Subject: FW: AB/12/21/PL -Old Bank House, 3 High Street, Arundel

Subject: AB/12/21/PL -Old Bank House, 3 High Street, Arundel

Project:-	Old Bank House 3 High Street Arundel West Sussex		
Title:-	Block Plan		
Client:-	Moor Construction Ltd		
Scale:-	1:500 (@A3)		
Drawn By:-	PJD	Checked By:-	
Date:-	12/02/21	Date:-	
Job.No:-	200042	Drg.No:-	21

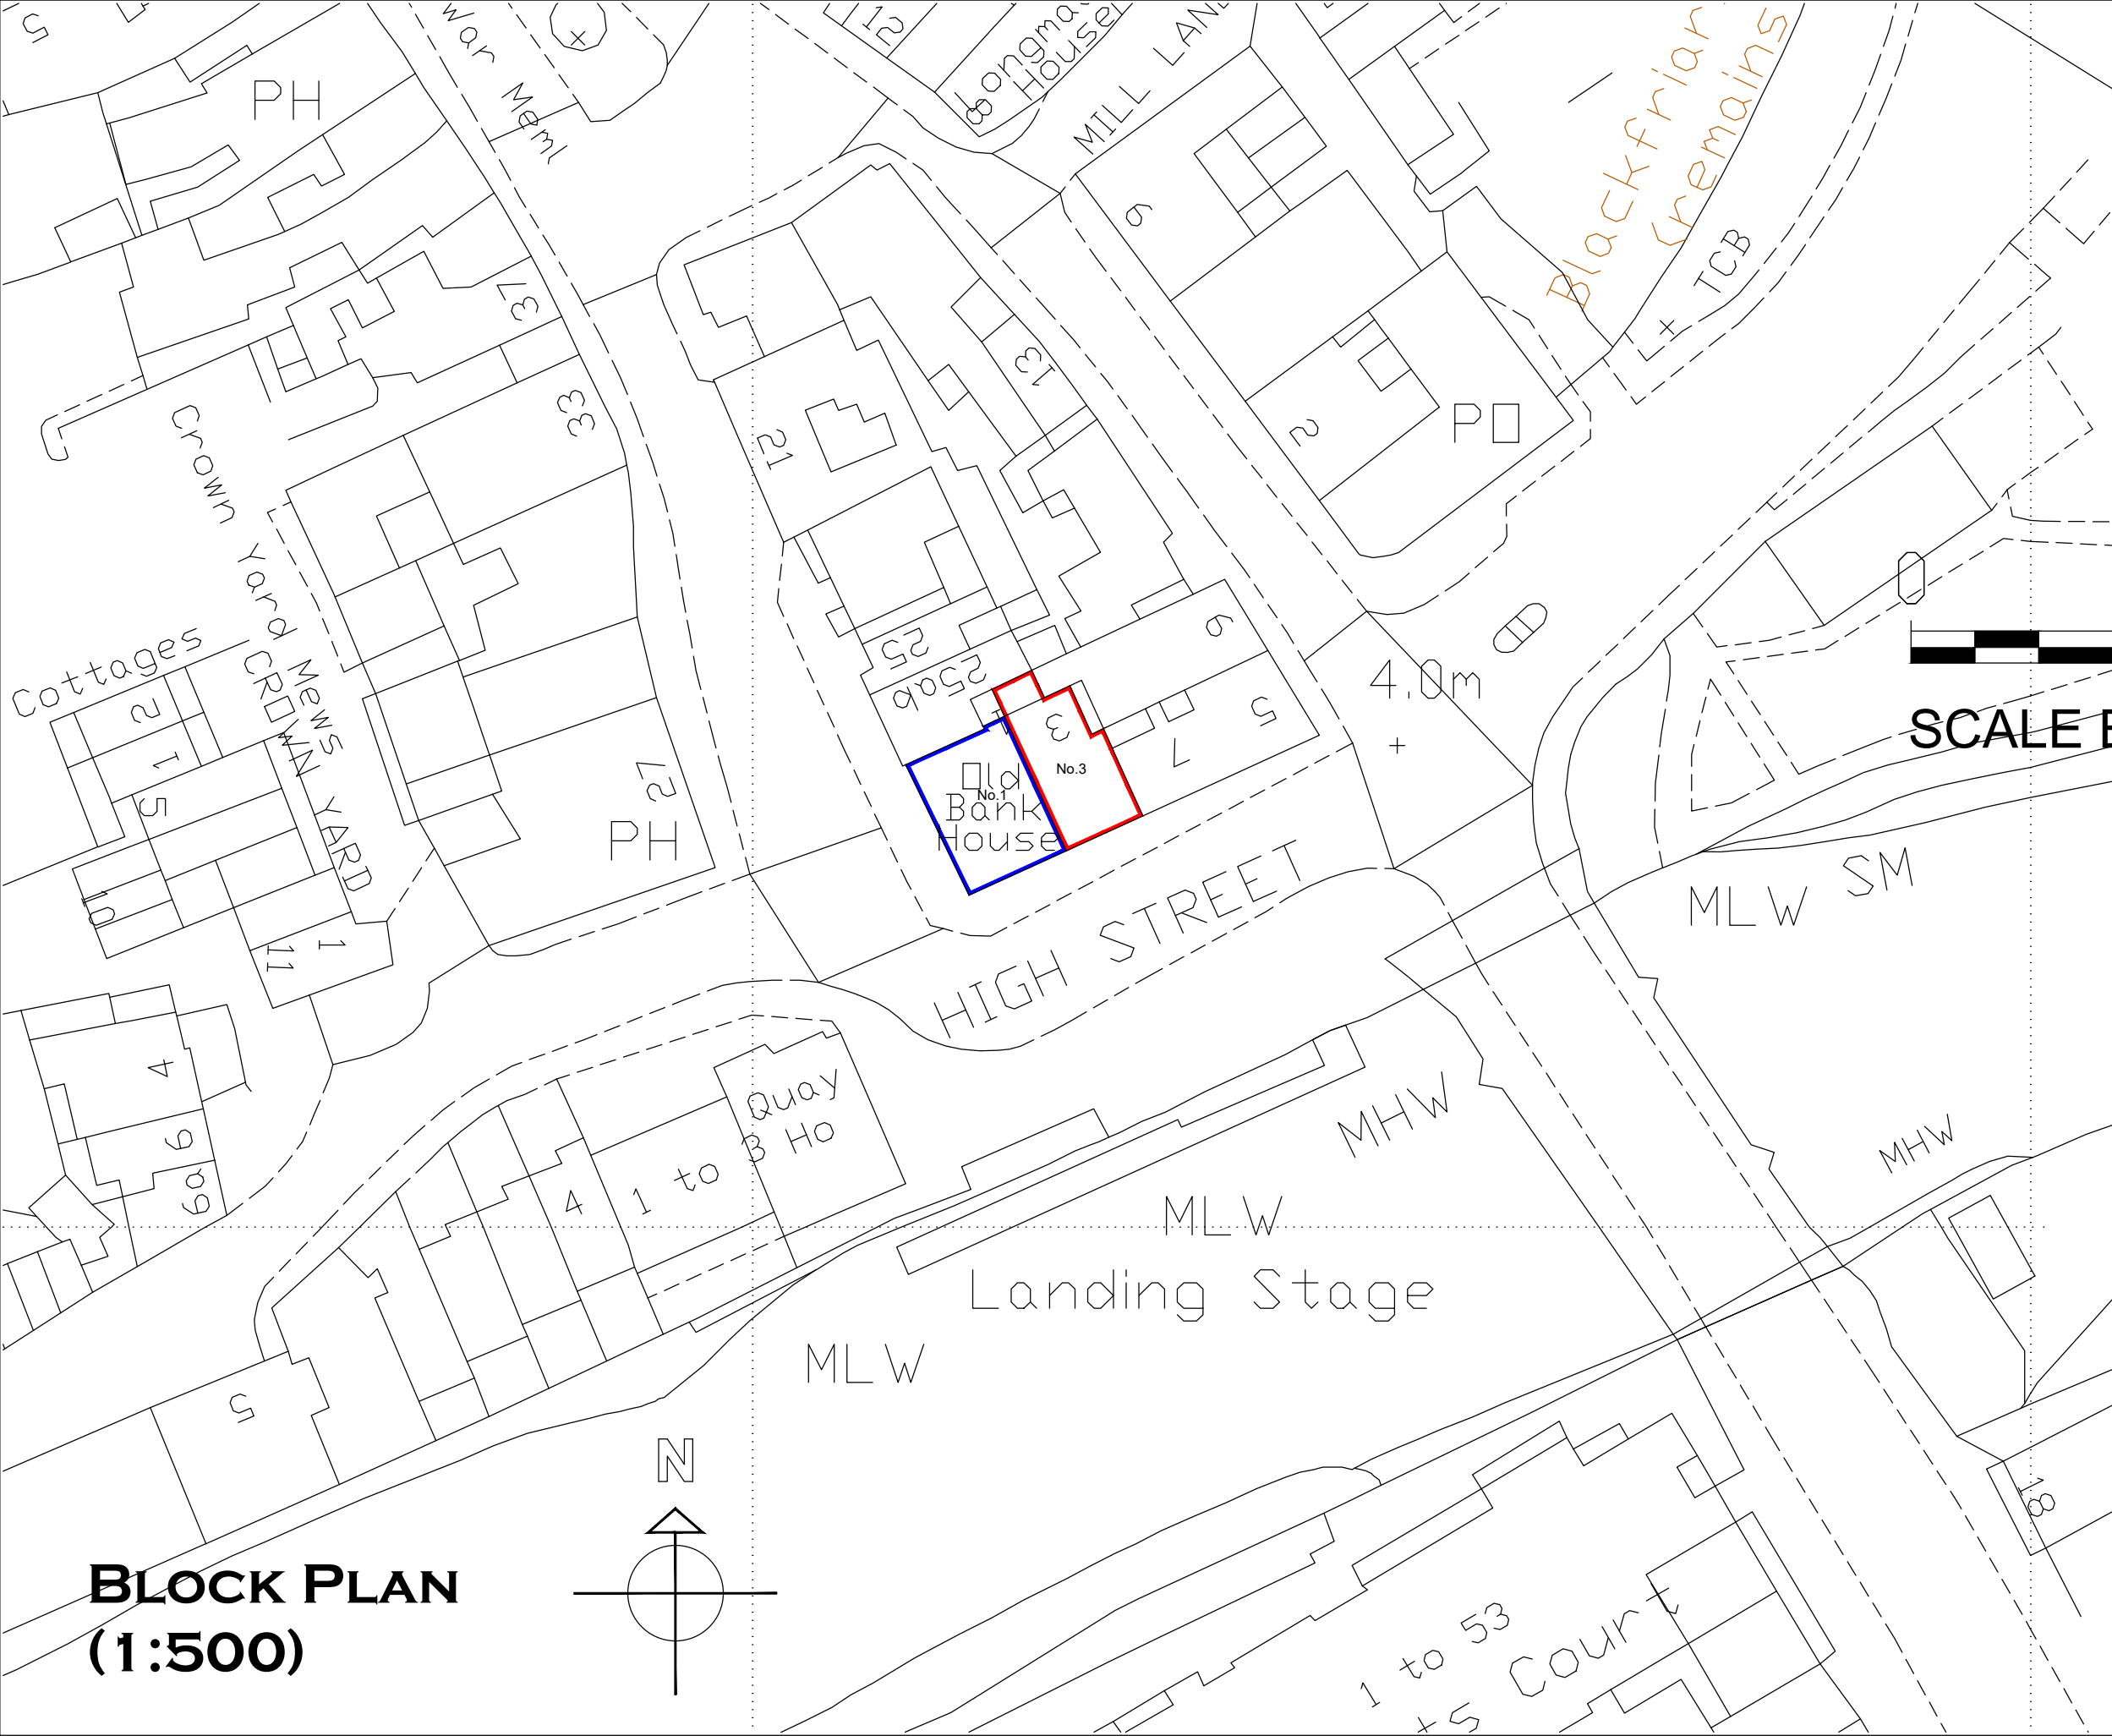
I note that the above application includes the provision of new steps on the pavement and that this area is excluded from the red edge of the application site. I apologise that this was not picked up at registration stage. I am therefore requesting that a revised floor plan and site location/block plan are submitted and Notice is served on WSCC as landowners and a new land ownership Certificate submitted. The application would be placed back on hold whilst this is undertaken, but we currently have no access to the planning database so this will be backdated from next week when the system is back up and running and the advertising period will be amended accordingly from receipt of this information.
